TOWN AND COUNTRY PLANNING ACT 1990

APPROVAL REQUIRED BY CONDITION OF PERMISSION

Reference:	H07-0594-23	Date of Decision:	23rd November 2023
Applicant:	Mr A Zdroba 32 Hillgate Gedney Hill Spalding Lincolnshire PE12 0NN		
Location:	32 Hillgate Gedney Hill Spalding		
Description:	Details of first floor window, additional tree planting and surface water disposal (Conditions 3, 4 and 6 of H07-0987-22)

Rev A 04/11/20 Landscaping added
Project:
Detached Garage
Client:
Rebeca Zdroba
Address:
32 Hillgate
Gedney Hill
Spalding
PE12 ONN
Drawing Title:
Site Plan
Drq No: 03
Scale: 1:500 @ A3
Date: Mar 2020

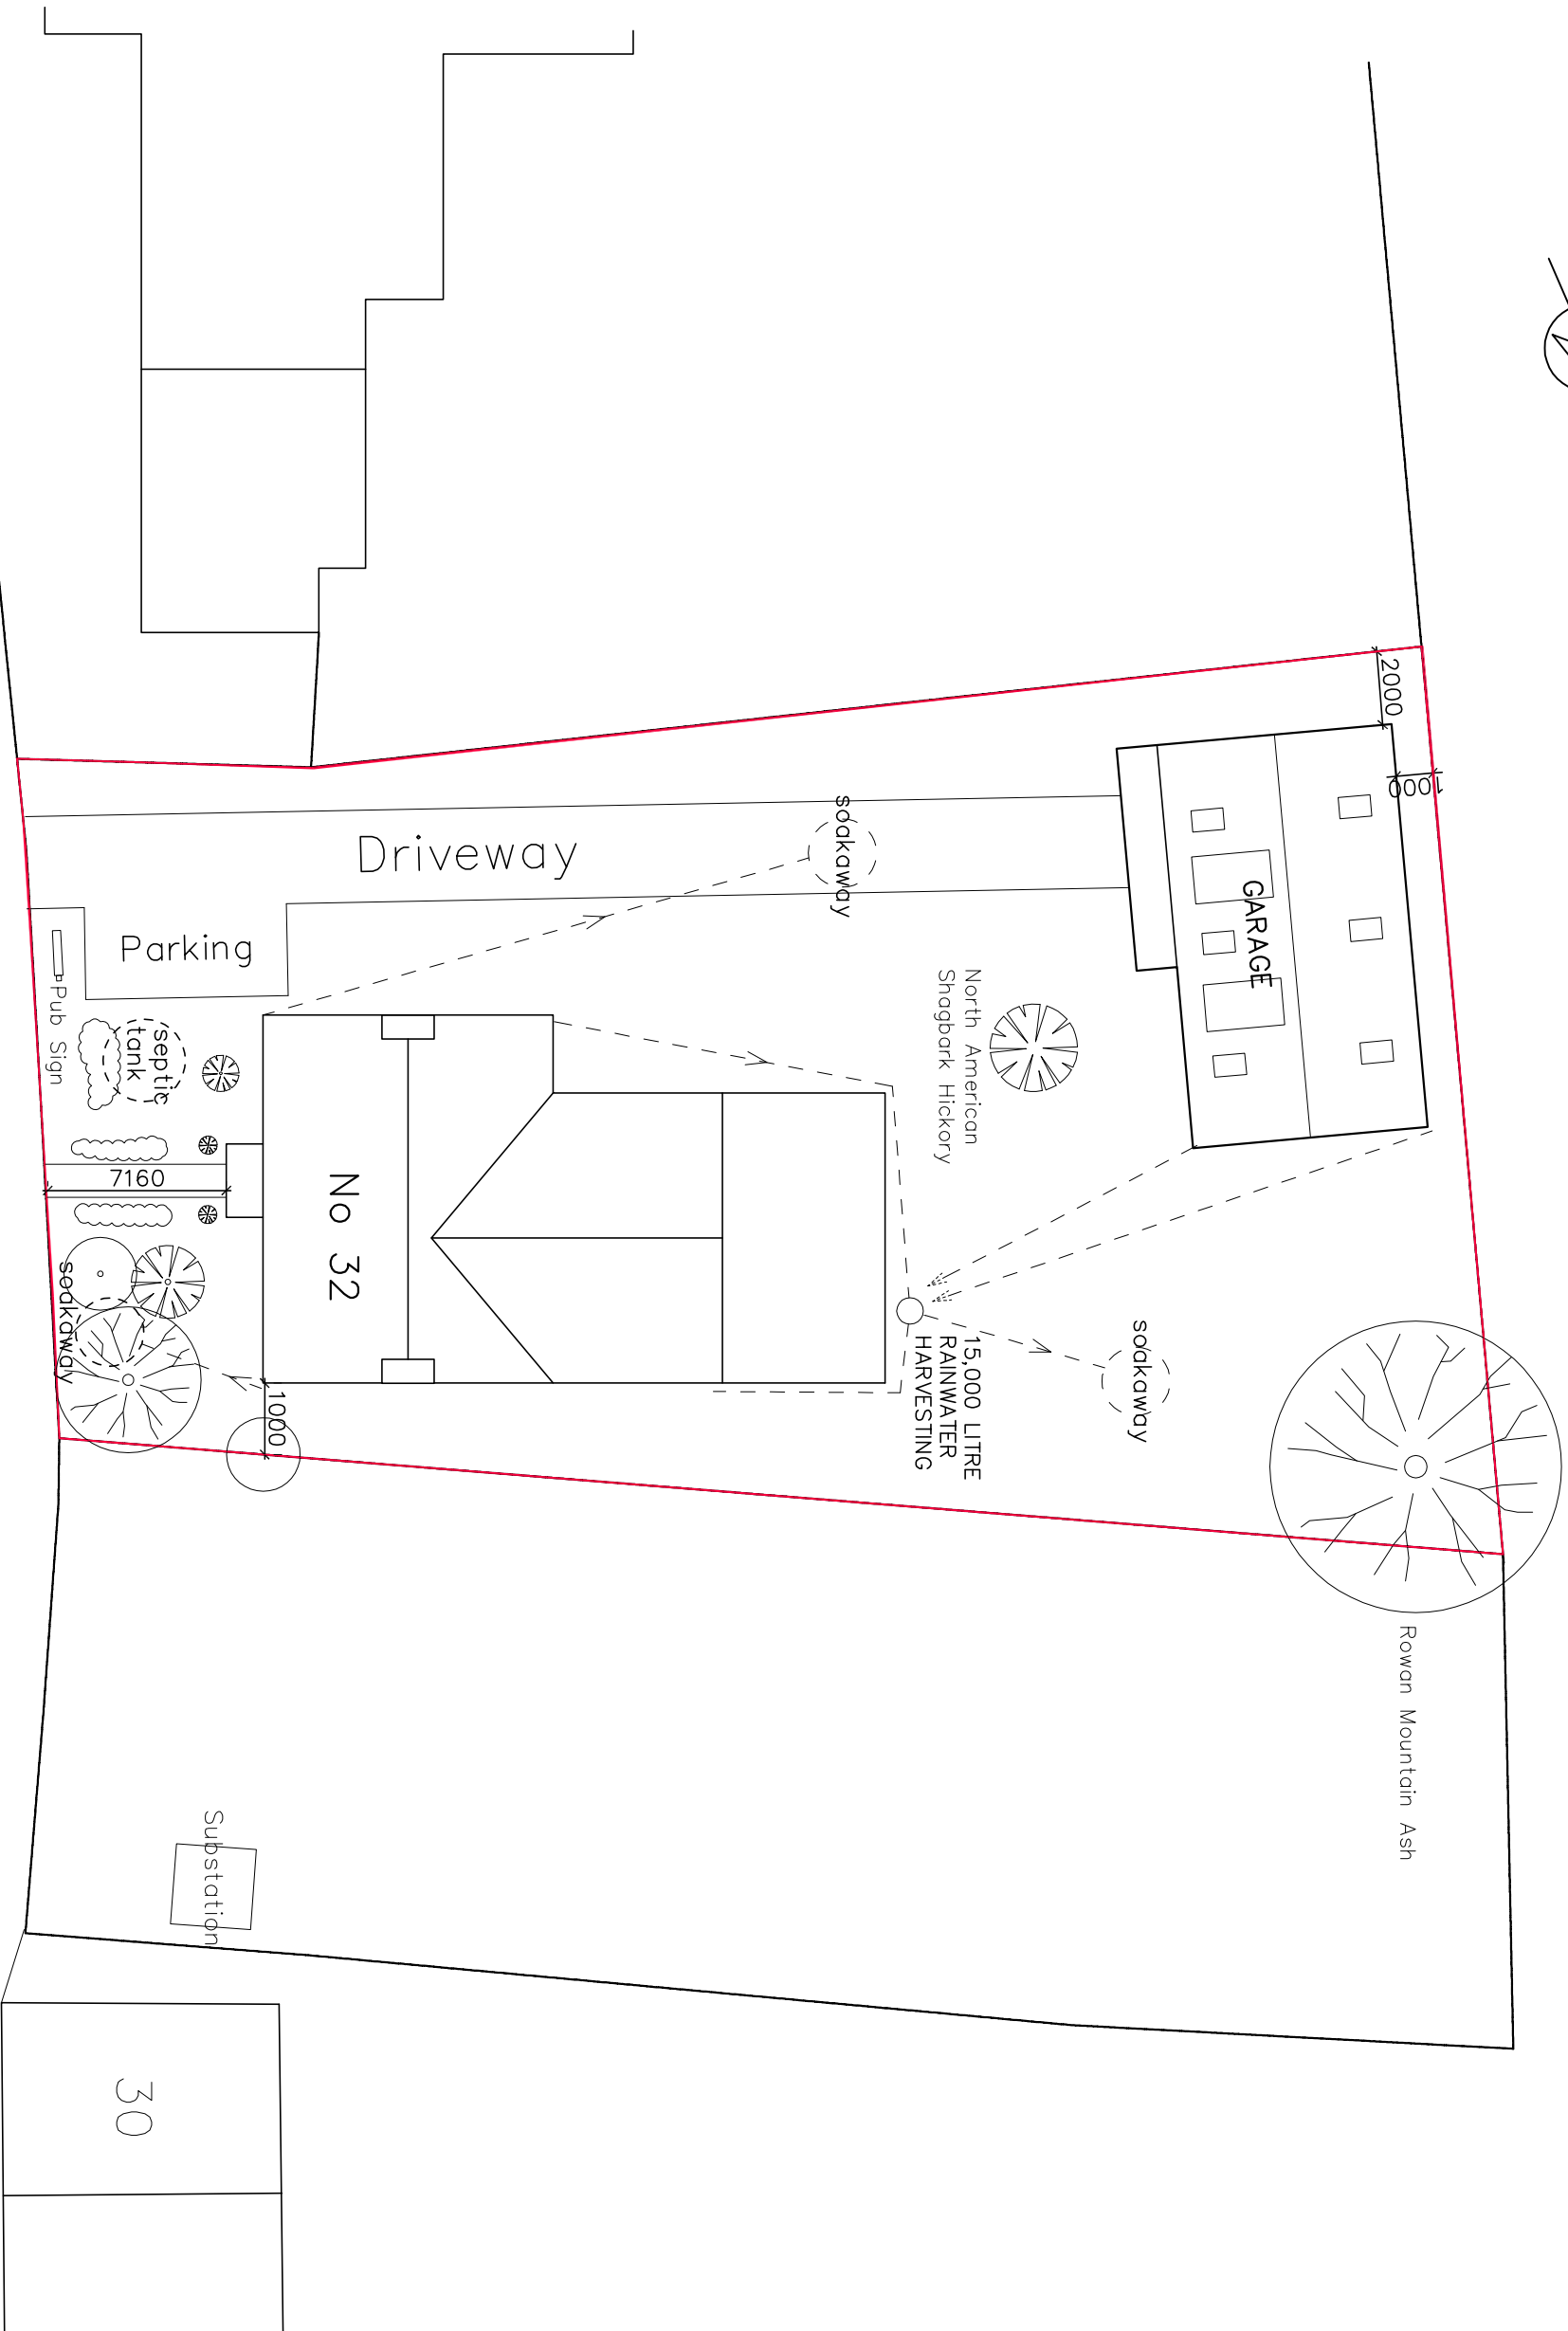
- 1 In the opinion of the Local Planning Authority it has not been satisfactorily demonstrated that a soakaway(s) will function satisfactorily in this location. The proposal therefore fails to accord with Policies 2 and 3 of the South East Lincolnshire Local Plan, 2019. The latter indicate that new development should be of a high standard of design with a high standard of amenity for future occupiers and not cause localised flooding. Paragraph 130 of the National Planning Policy Framework, 2023 states that new development should have a high standard of amenity for existing and future users.

A new condition compliance application will need to be submitted to discharge conditions 3, 4 and 6 of H07-0987-22, accompanied by infiltration testing required to demonstrate that the ground is suitable for a soakaway(s) and, if so, what size/design is required.
